WEST SUSSEX COUNTY COUNCIL CONSULTATION

TO:	Arun District Council FAO: Simon Davis
FROM:	WSCC - Highways Authority
DATE:	1 August 2019
LOCATION:	Yapton Metal Company Burndell Road Yapton BN18 0HP
SUBJECT:	Y/61/19/PL Application for variation of condition imposed on planning permission Y/53/16/PL relating to condition no.4 - amendment to site layout. This application affects the setting of a Listed Building.
RECOMMENDATION:	Advice

West Sussex County Council, in its capacity as the Local Highway Authority (LHA), have been consulted on variation of condition on Y/53/16 (4 x dwellings), to amend site layout.

c			
b			
a			
Amendments		by	Date
Job Title		118 Burn/ADS/PJ	
Drawing			
Access Turning Proposed			
Scale: 1:200 @ A3			
Drg.No.		ADS-003P	*
Drawn by:		NJH	
Issued to:		Client/Consult.	
Status:		Planning	
Date		04.07.19

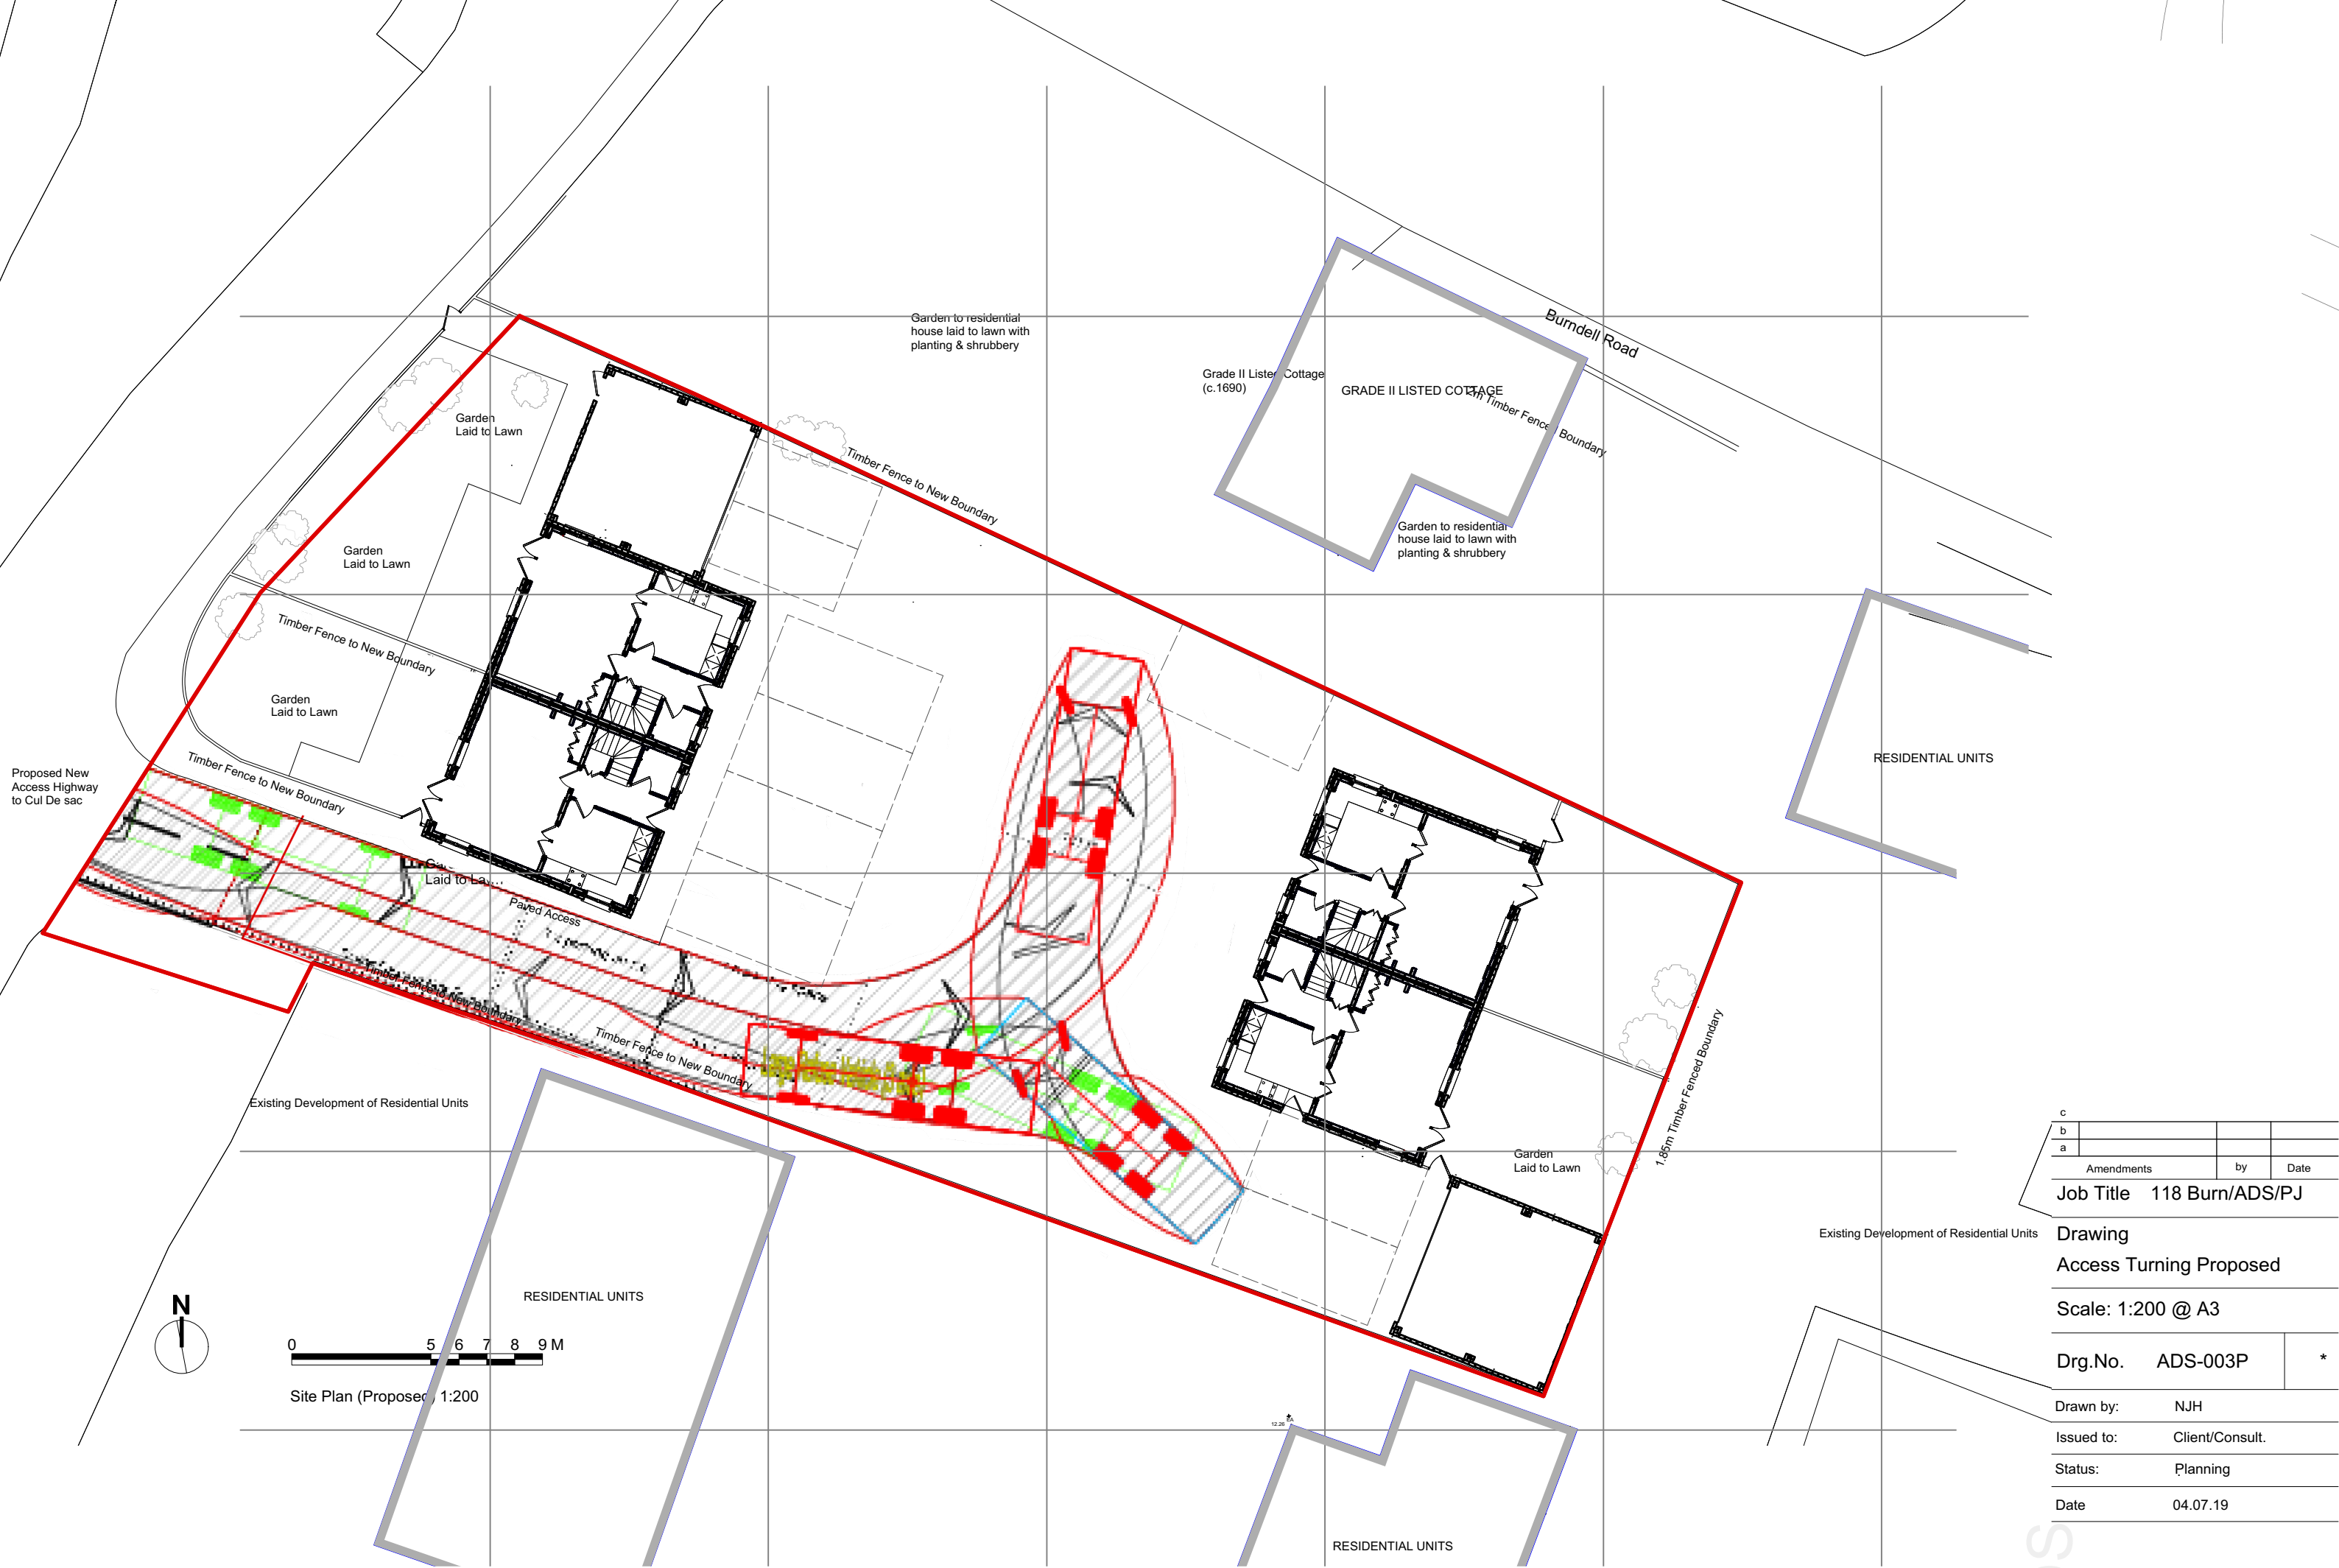
The LHA does not raise any highway safety concerns to amended site layout, which includes re-positioning of proposed car parking spaces. Nevertheless, from an inspection of the access tracking plan it is noted that the route for a refuse vehicle is restrictive in relation to the proposed car parking spaces. The Local Planning Authority (LPA) may wish to gain the views of waste collection authority with respect to proposed waste collection arrangements and whether this would realistically take place within the site or from adjoining access road, where a reverse manoeuvre in to the site could take place in this scenario.

PLAN DRAWN OF EXTRACT OF APPROVED PLAN ADS-013P

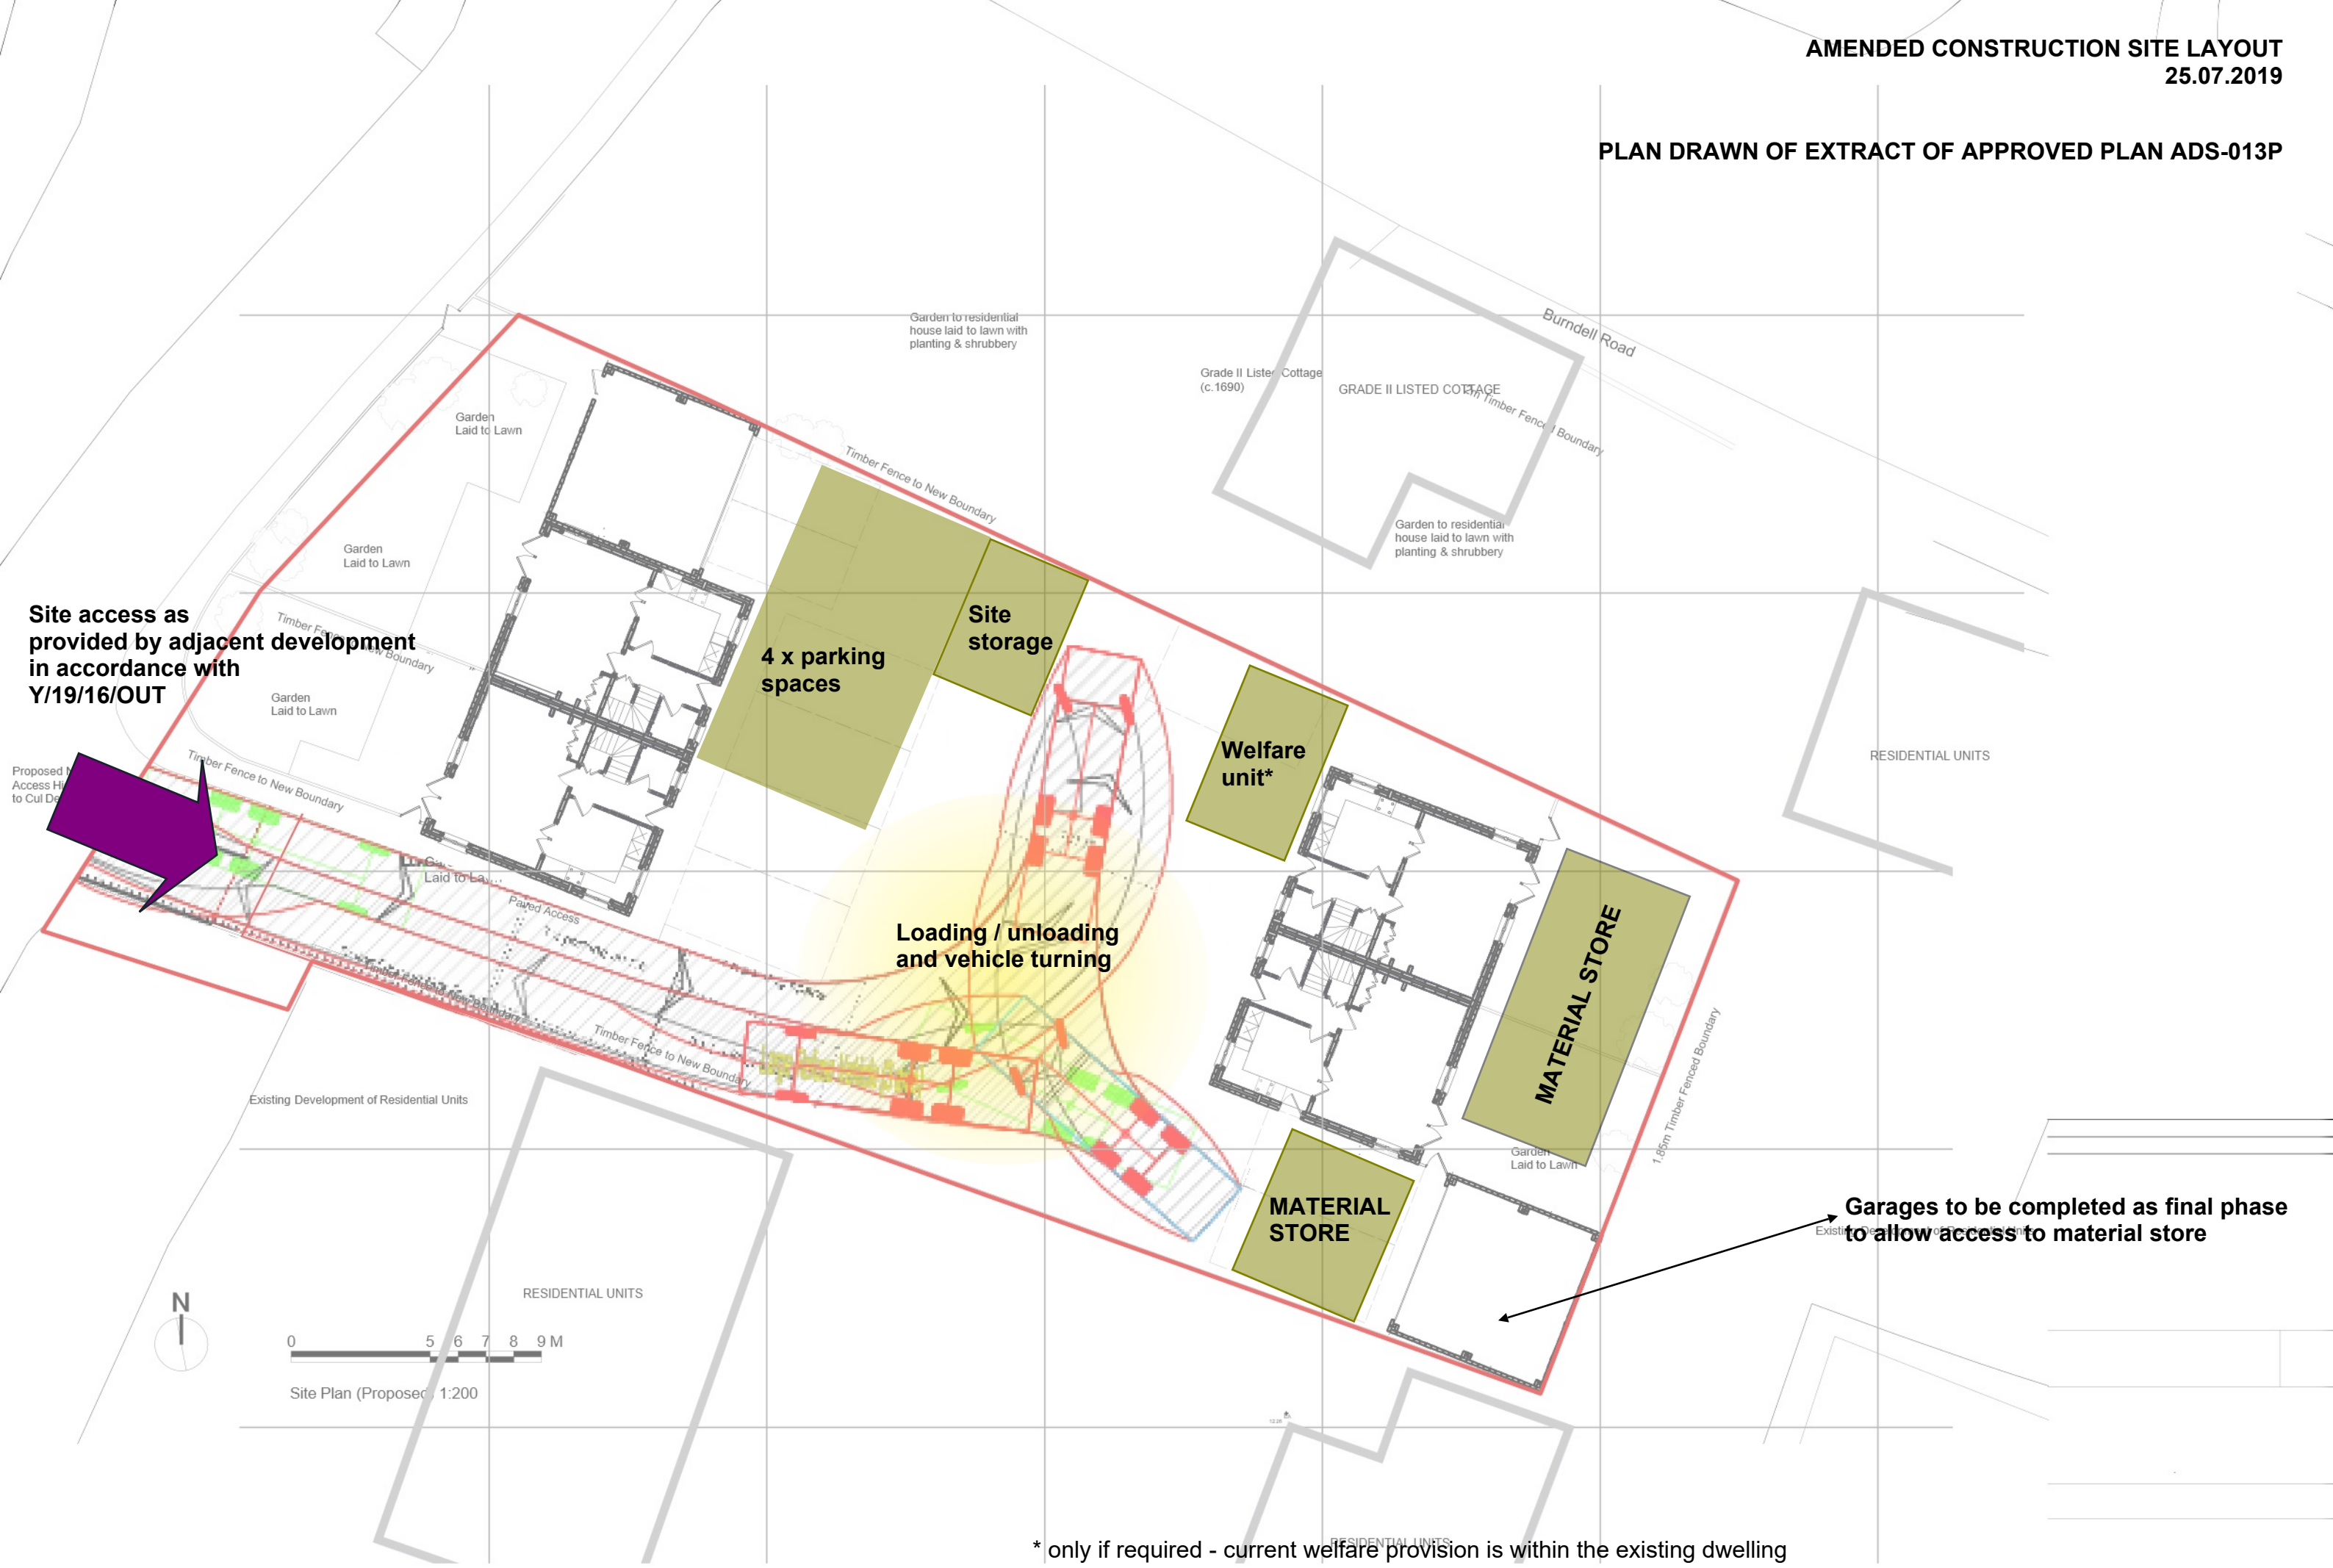
It is also worth noting that the construction site set up previously commented on under Y/42/19 would require amending as placement of car parking/ materials/ unloading areas would be expected to differ with this revised arrangement.
